From: Simon Davis
Sent: 27 November 2025 11:00
To: 'Kate Chapman' [REDACTED]
Subject: RE: Land at West Barn, Old Dairy Lane - AL/107/25/PL

Further to the changes you made to the location and block plans, it has been brought to my attention that your red edge drawing suggests that land is part of Old Dairy Lane when in fact it is parking to East Barn (East Barn is not marked on the below but is directly above The Hovel and borders Old Dairy Lane). The below is a LR plan I have seen sent on the left and your red edge plan on the right. I have also been sent the attached purporting to show your clients ownership in yellow. I say purporting because I don't have access to the LR title deeds etc. to check this myself.

CLIENT BioDot		
PROJECT New office building adjacent to West Barn Norton Lane, Norton, Aldingbourne		
DRAWING TITLE Block Plan and Location Plan		
DATE Feb 2025	SCALE As shown	DRAWN BY
		CHECKED BY
JOB NO. 25 / 01	DRAWING NO. 04	REVISION Rev C

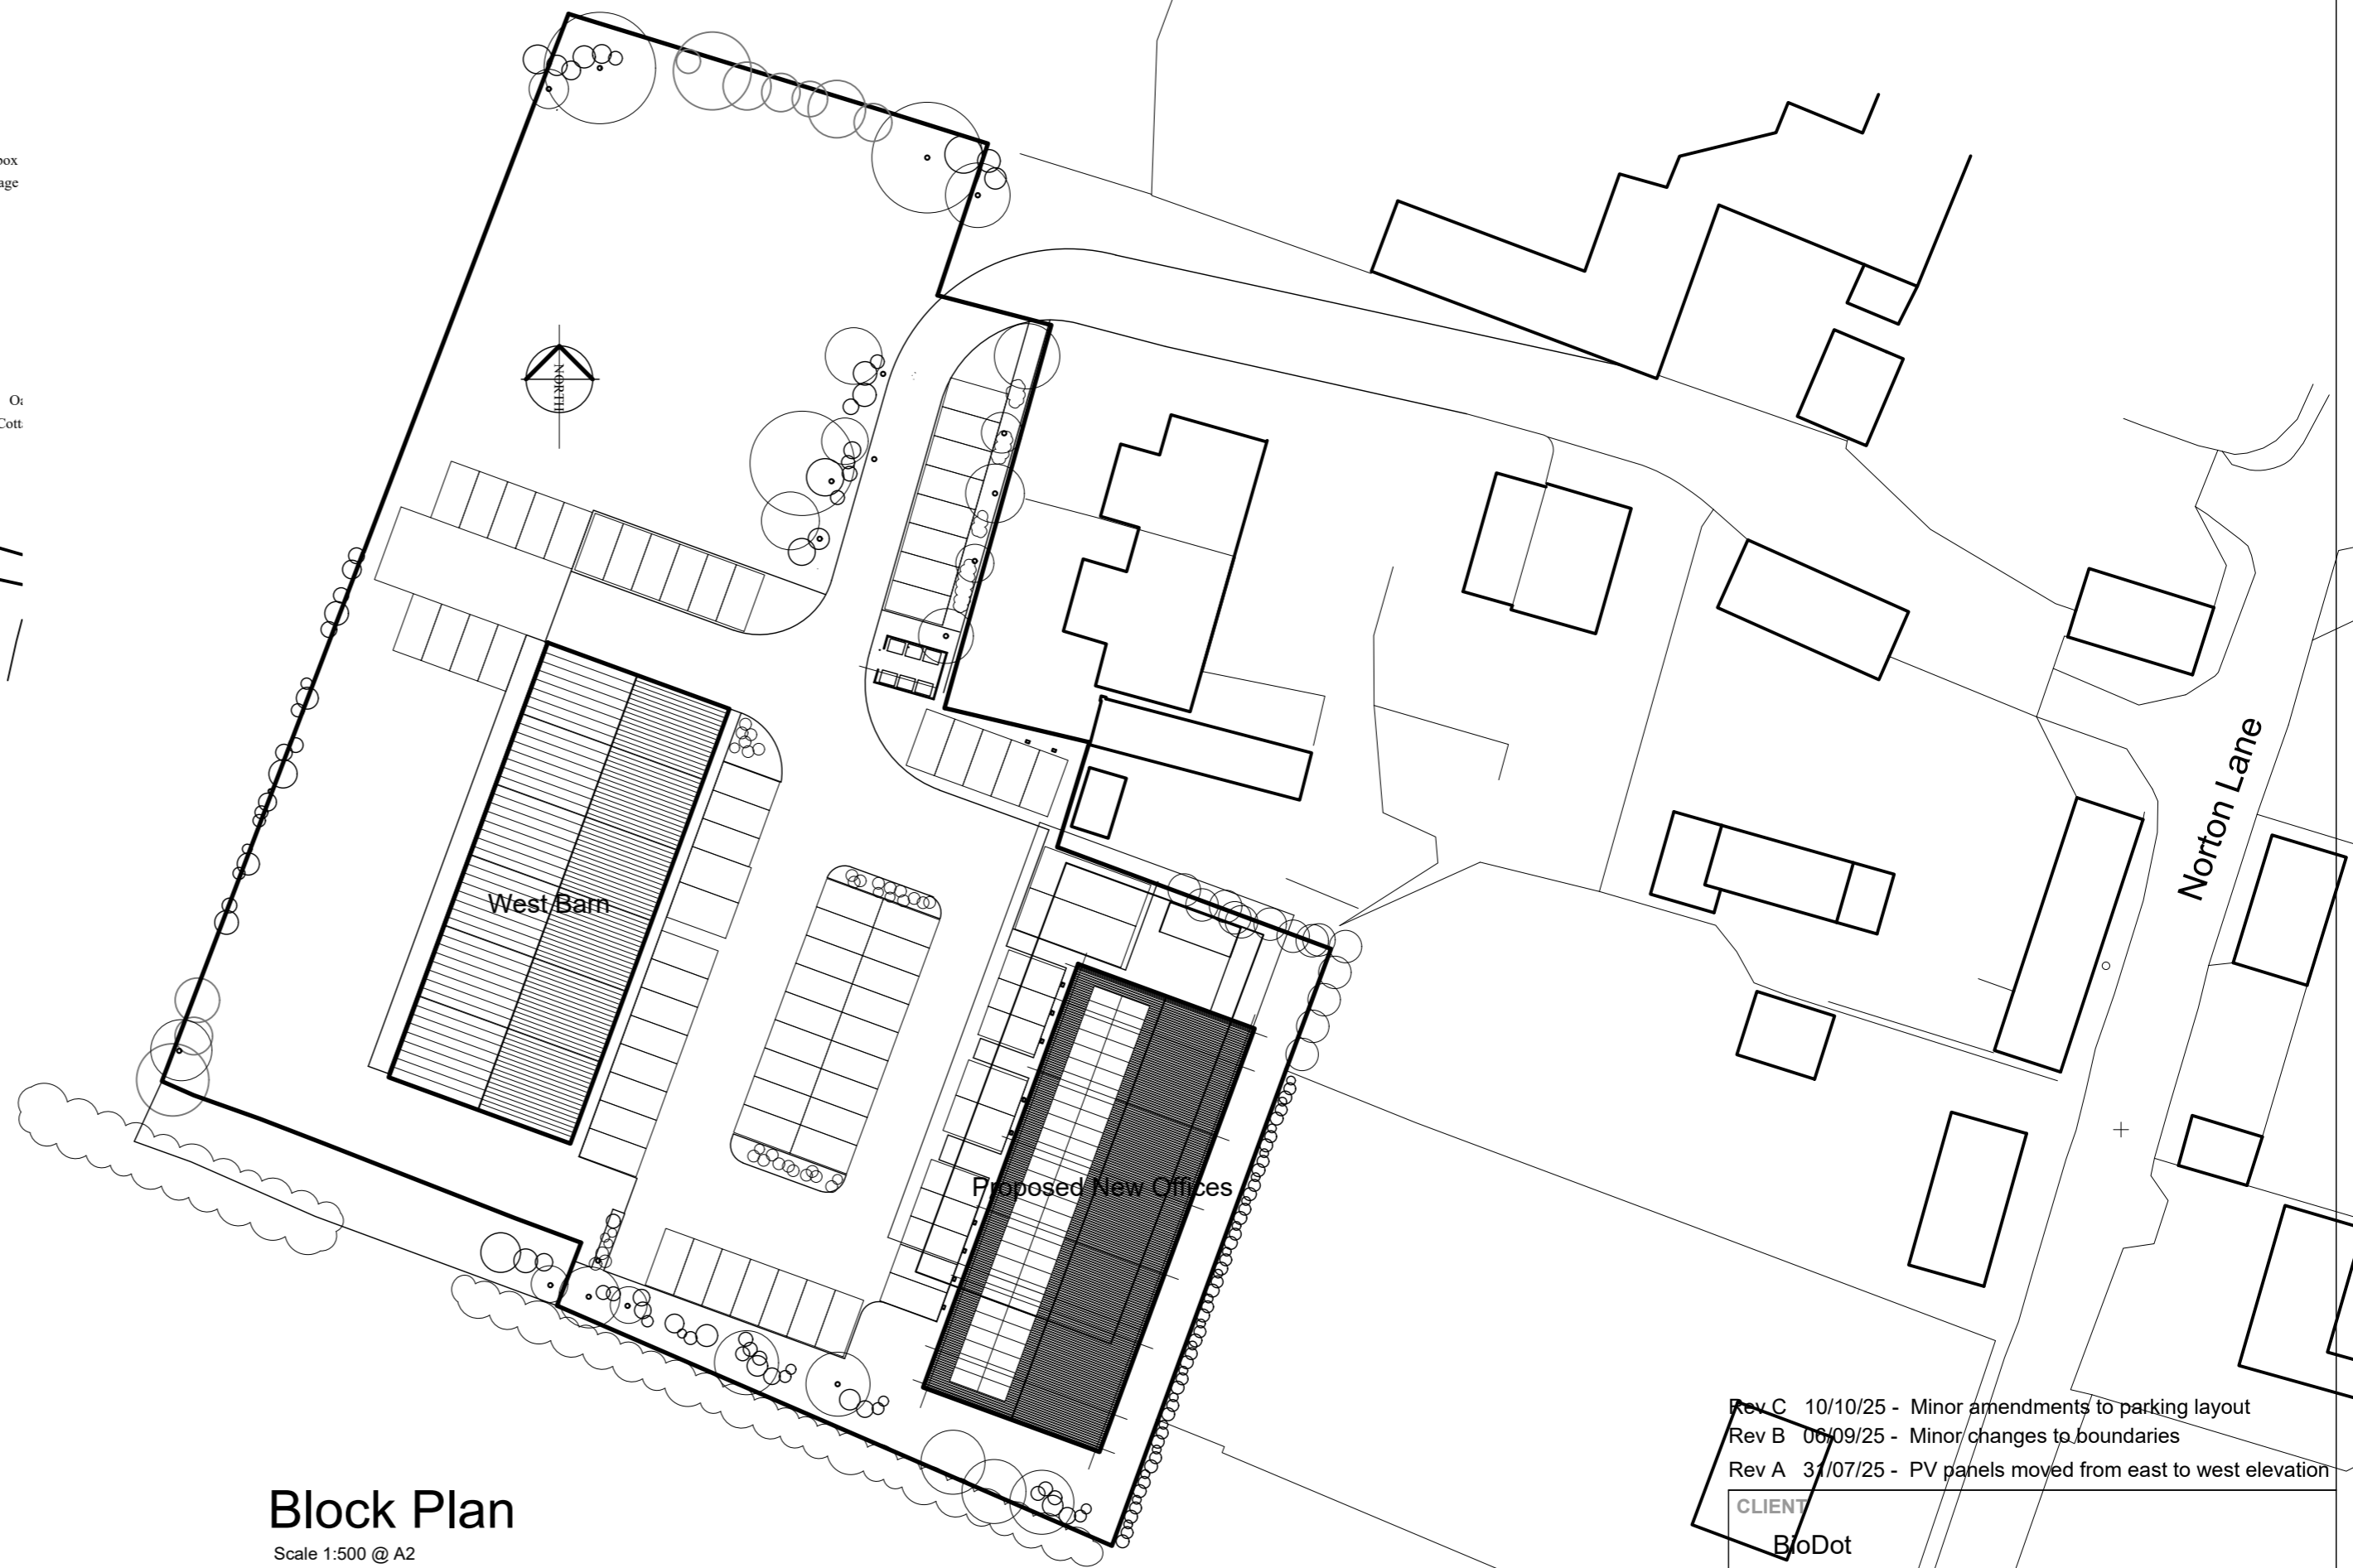
If the red edge has indeed been shown to include land not in your client's ownership, then can you either amend the red edge or serve notice on the owners of the land.
